Our Ref: EP/42/17/PL
Your Ref:

Town & Country Planning Act 1990 (as amended)
Town and Country Planning (Development Management Procedure) (England) Order 2015
Application for Planning Permission

Development Alterations to existing public conveniences including provision disabled facilities and ramped access to toilet.
Location Public Conveniences (Arun Village Hall) Sea Road East Preston

Site Location Plan (1:1250)

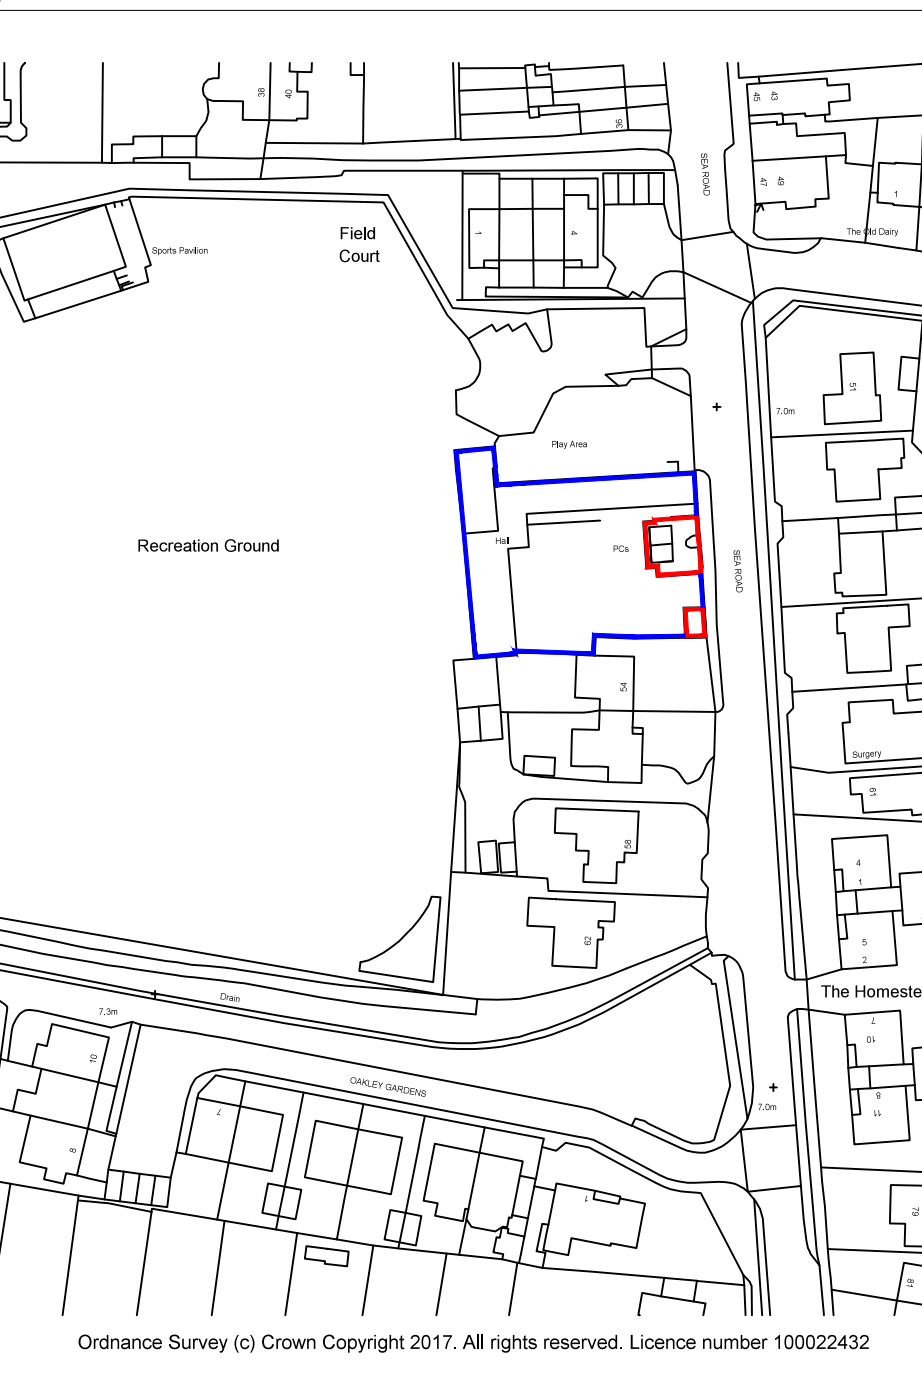
Location Plan - Amend

Please submit 1 electronic or 3 paper copies of an amended location plan at a scale of 1:1250 to include a blue edge around any adjoining land under the same ownership. Further details of what must be included on the plan can be found in the National Validation Requirements.

Site Block Plan (1:500)

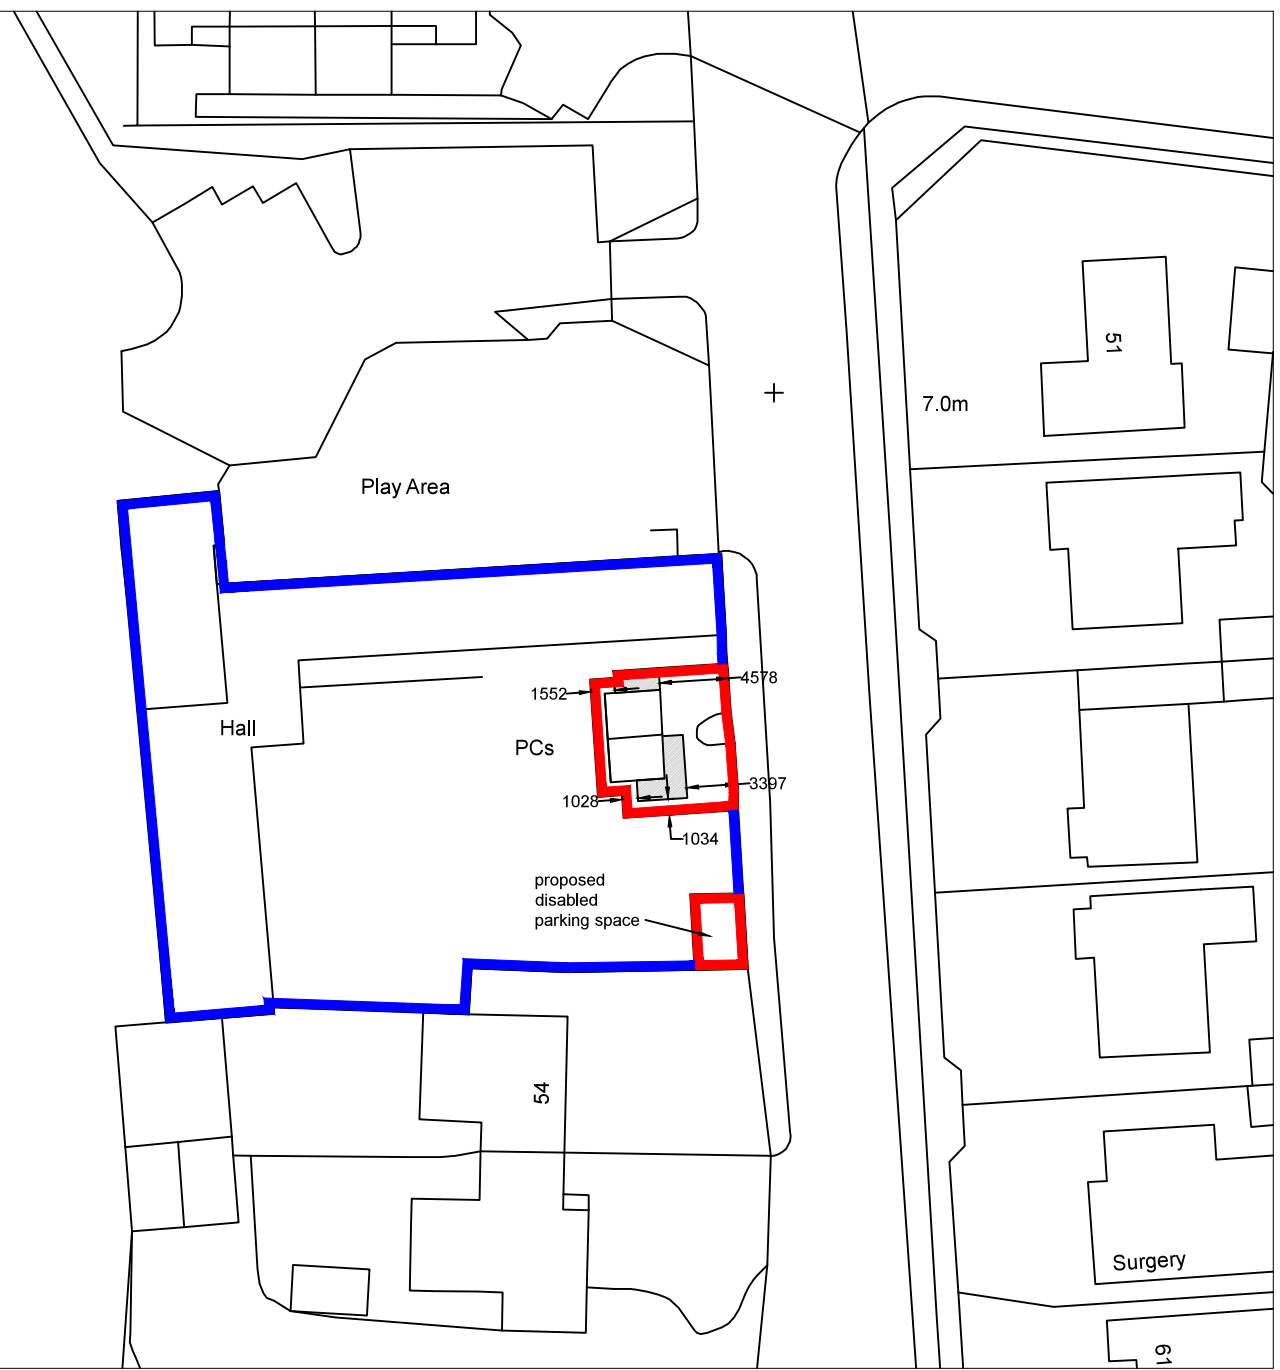
Block Plan - Amend

Please submit 1 electronic or 3 paper copies of an amended block/site plan at a scale of 1:500 or 1:200, coloured to accord with the amended Location plan. Further details of what must be included on the plan can be found in the National Validation Requirements.
